Reference No:	2023/62/93756/W
Site Address:	42, Manchester Road, Slaithwaite, Huddersfield, HD7 5JA
Description:	Partial demolition of rear conservatory and erection of single storey rear extension
Recommending Officer:	Molly Storer

HOUSEHOLDER DELEGATED REPORT

Application Number	2023/93756
Location	42, Manchester Road, Slaithwaite, Huddersfield, HD7 5JA
Proposal	Partial demolition of rear conservatory and erection of single storey rear extension
Publicity end date	12 th February 2024
Number of representations received	None.
Kirklees Local Plan Allocation/Designation	Unallocated in the Kirklees Local Plan
Extension to Time (EoT)	No EoT Date:
Recommendation	Conditional Full Permission

Drawing Title_
AS PROPOSED, FLOOR PLANS + ELEVATIONS

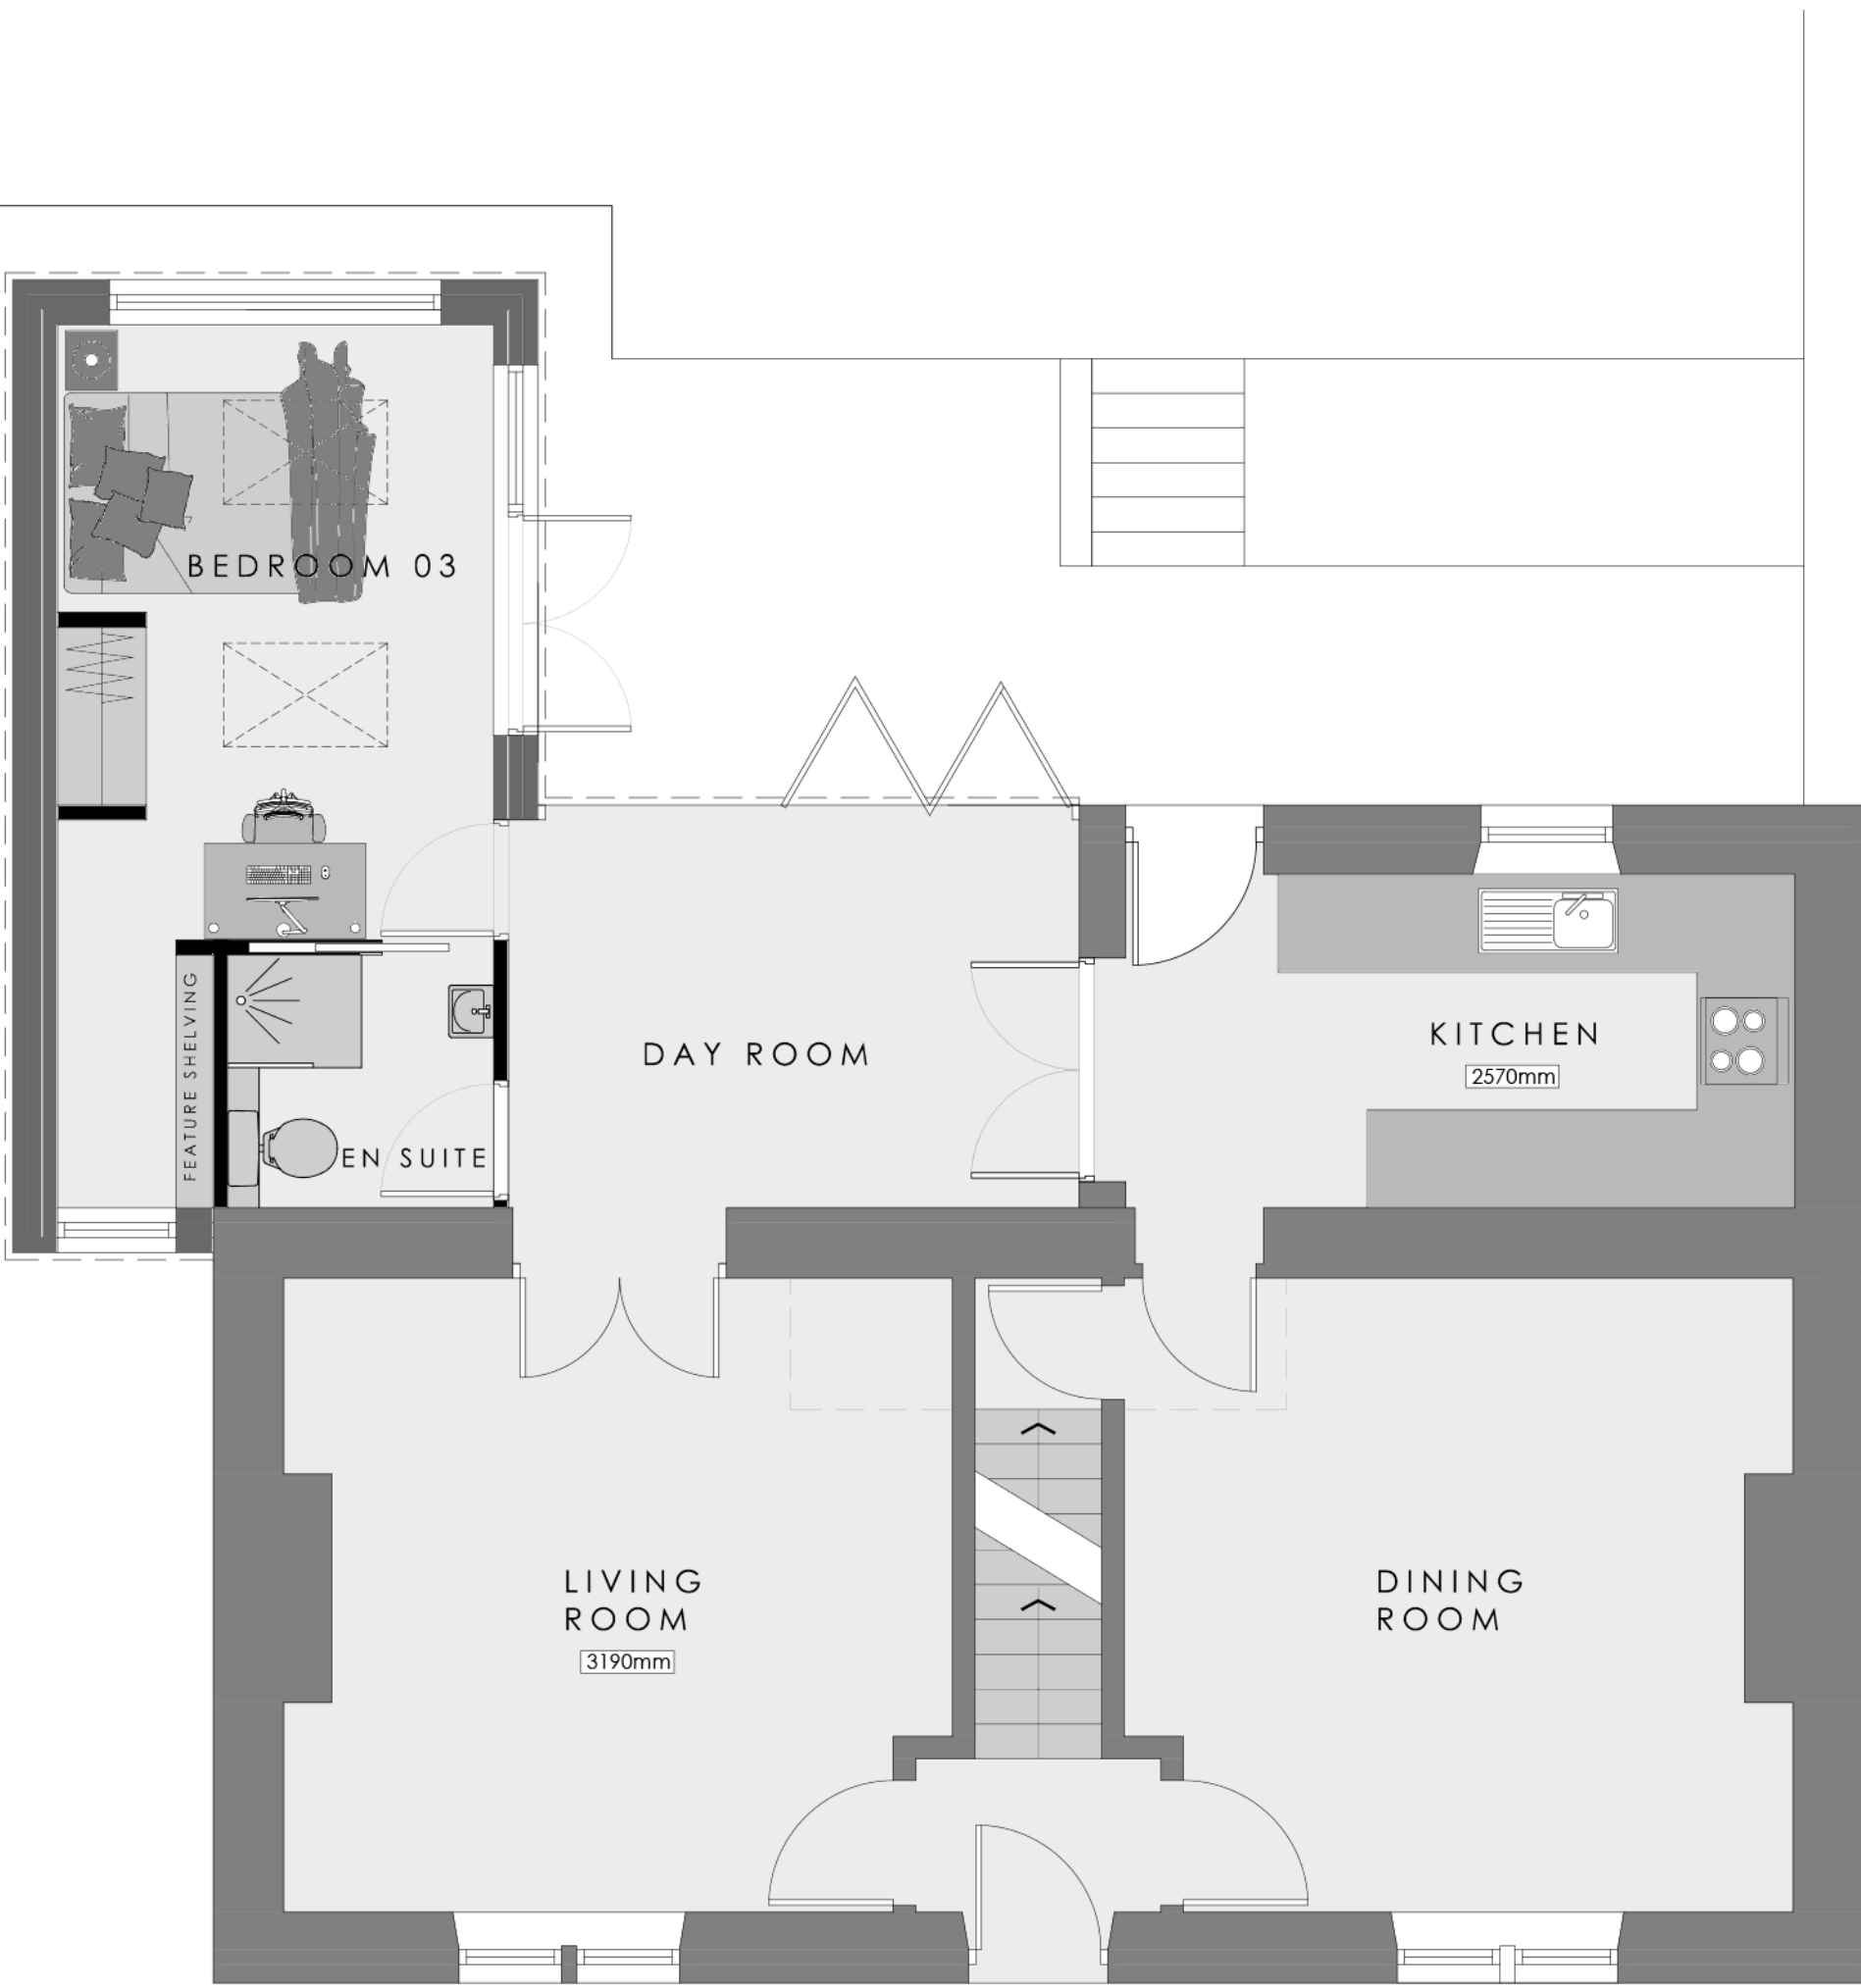
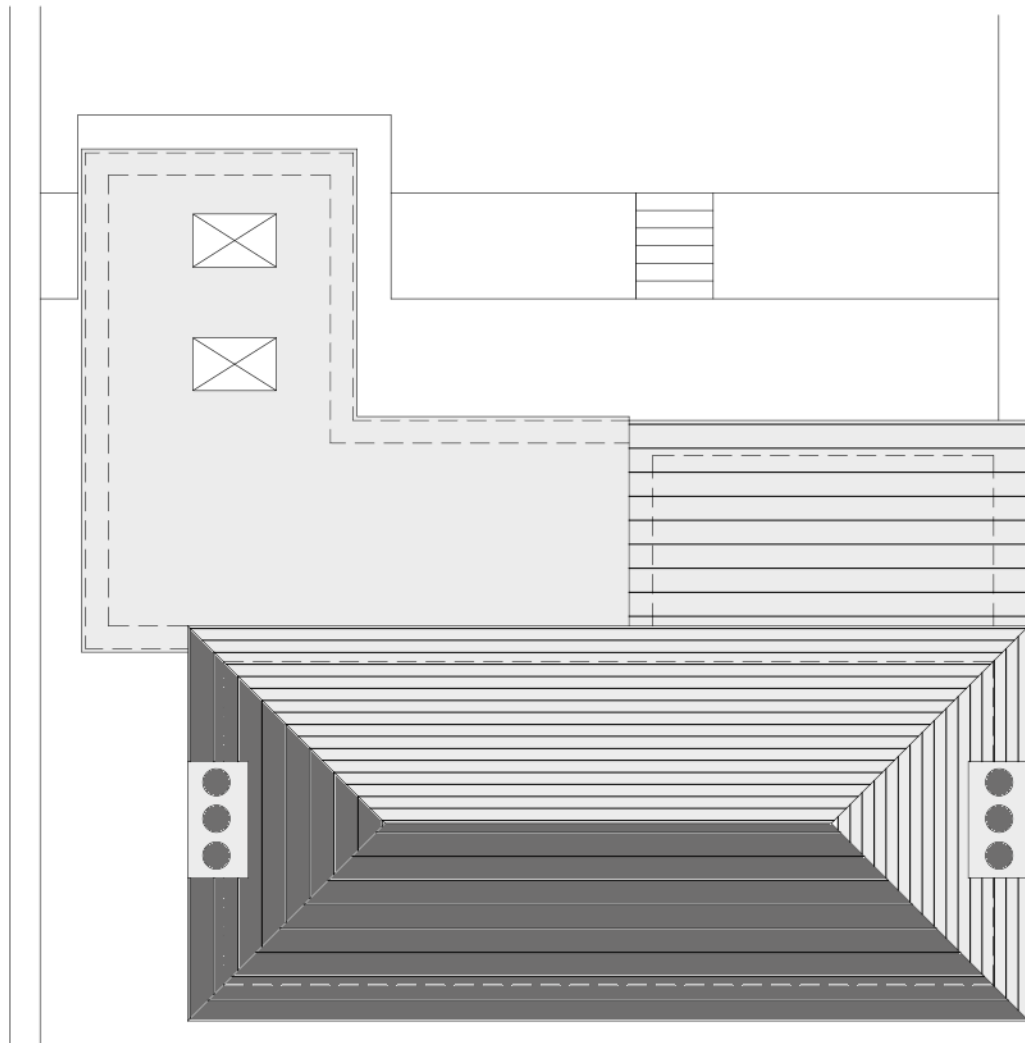
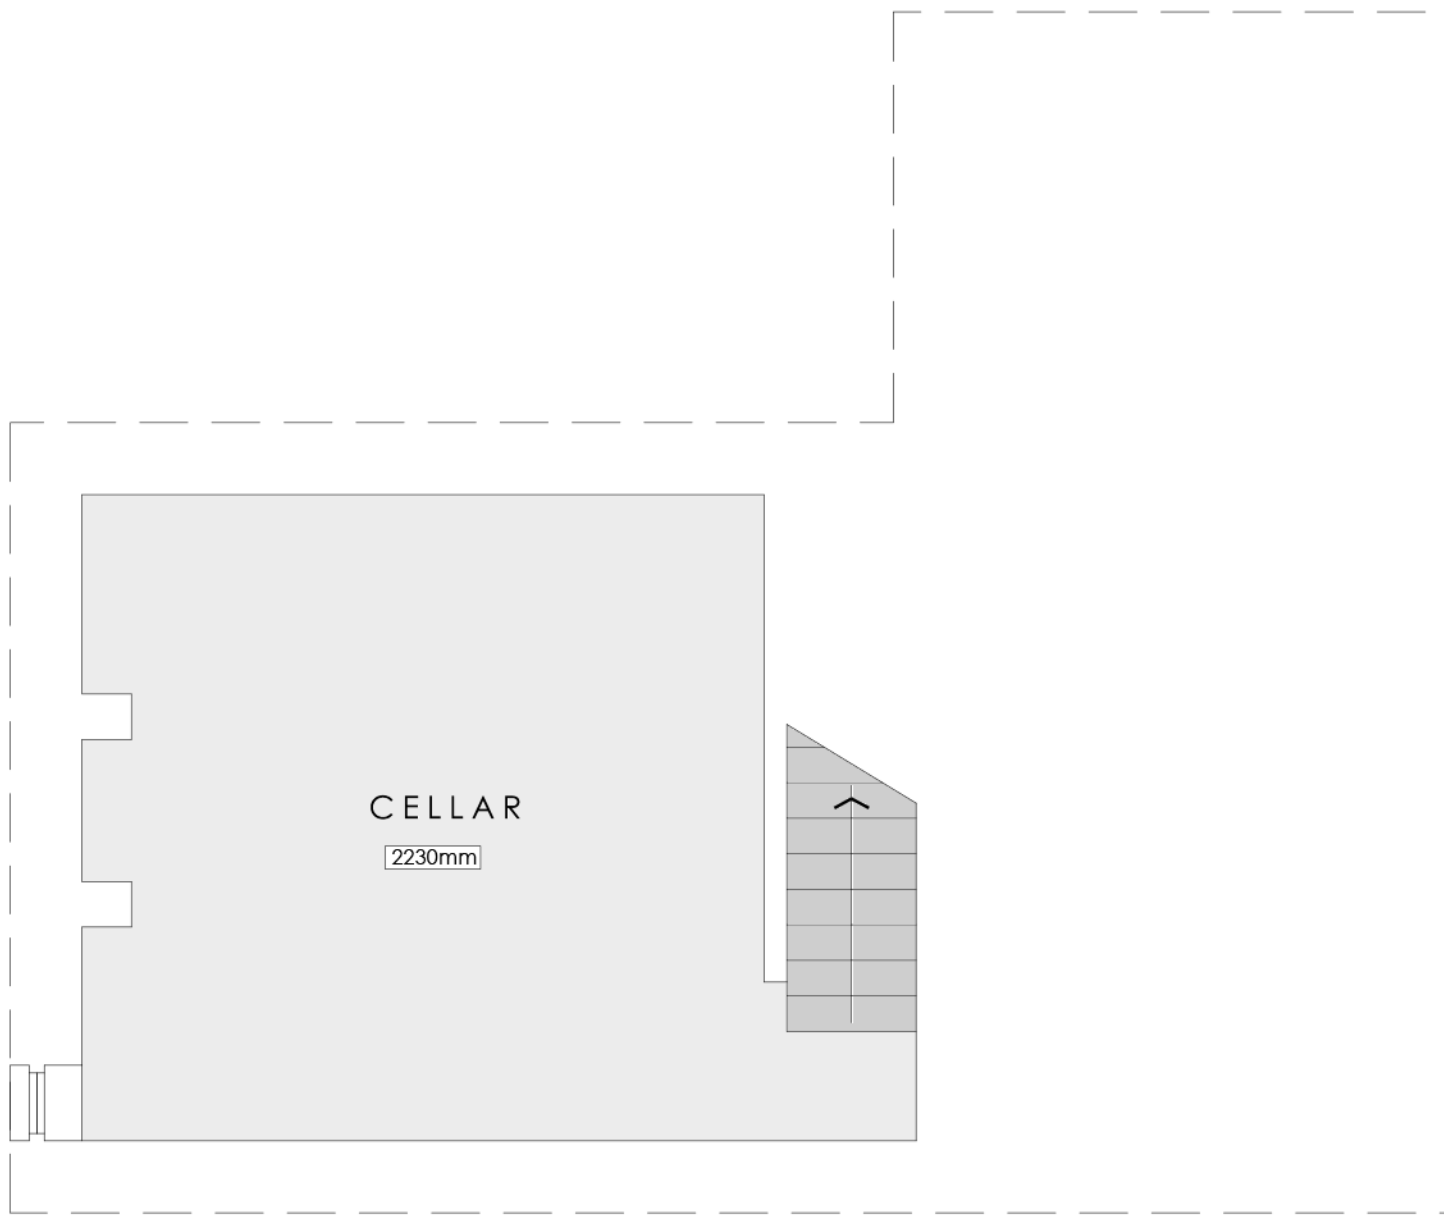
The extension in part will project 2.8m from the rear (east) elevation. The other part will project 3.3m from the rear (east) elevation. This is an 'L' shape configuration. The width of the extension will be 7m overall and this will project beyond the side (south) elevation. The overall height of the extension will be 3m with a flat roof design. This will create a day room and a third bedroom.

be in keeping with the scale and style of the original house	Yes, in part – due to being single storey in height and not impacting first floor windows the extension will be in keeping with the scale of the original house.	No - the style, with a different roof design and differing materials the extension will not completely be in keeping with the original style. However, the extension will replace

the unsympathetic conservatory addition in place of a better quality design. Therefore, in this isolated case is considered acceptable.
not normally cover more than half the total area around the original house (including previous extensions and outbuildings)	Yes – the extension will not cover more than half of the total area around the original house.	
not exceed 4 metres in height	Yes – the height of the extension will be 3 meters.	
not project out more than 3 metres from the rear wall of the original house for semidetached and terraces houses or by 4 metres for detached properties	Yes – the property is detached and the largest projection will be 3.3m from the rear.	
where they exceed 3m in length the eaves height should generally not exceed 2.5 meters		No – however due to the flat roof design limiting impact and only half the extension projecting more than 3m the extra 0.3m in length is considered acceptable.

retain a gap of at least 1 metre from a property boundary, such as a wall, fence or hedge		No – only a gap of 0.6m would be retained. However, this is considered acceptable due to the large ~2m fence and associated vegetation on the boundary screening the neighbouring property.

Facing materials and detailing	• KDP 9 of the SPD • Policy LP24 Design (d) (iii) of the KLP • Chapter 12 of the NPPF	Although the materials would not match the original dwelling black timber is considered acceptable due to the design being of a contemporary design and replacing the unsympathetic conservatory addition. This material would also lessen the immediate visual presence of the structure.	✓

Roof style	• KDP 1 and 2 of the SPD • Policy LP24 Design (a), (c) and (d) of the KLP • Chapter 12 of the NPPF	Flat roof design, ok to limit the scale.	✓
Window proportions	• KDP 1 and 2 of the SPD • Policy LP24 Design (a), (c) and (d) of the KLP • Chapter 12 of the NPPF	Large bi-folding doors and a smaller window on the rear (east) elevations facing into the garden. A full length window on the front (west) elevation and a full length window and a smaller single window in the side (south) facing elevation. Appear acceptable with the chosen design.	✓
Accessibility for all users	• KDP 17 of the SPD • Policy LP24 Design (f) • Chapter 12 of the NPPF	Private domestic extension – no alterations to general access arrangement. External access to the rear of the property will remain.	✓
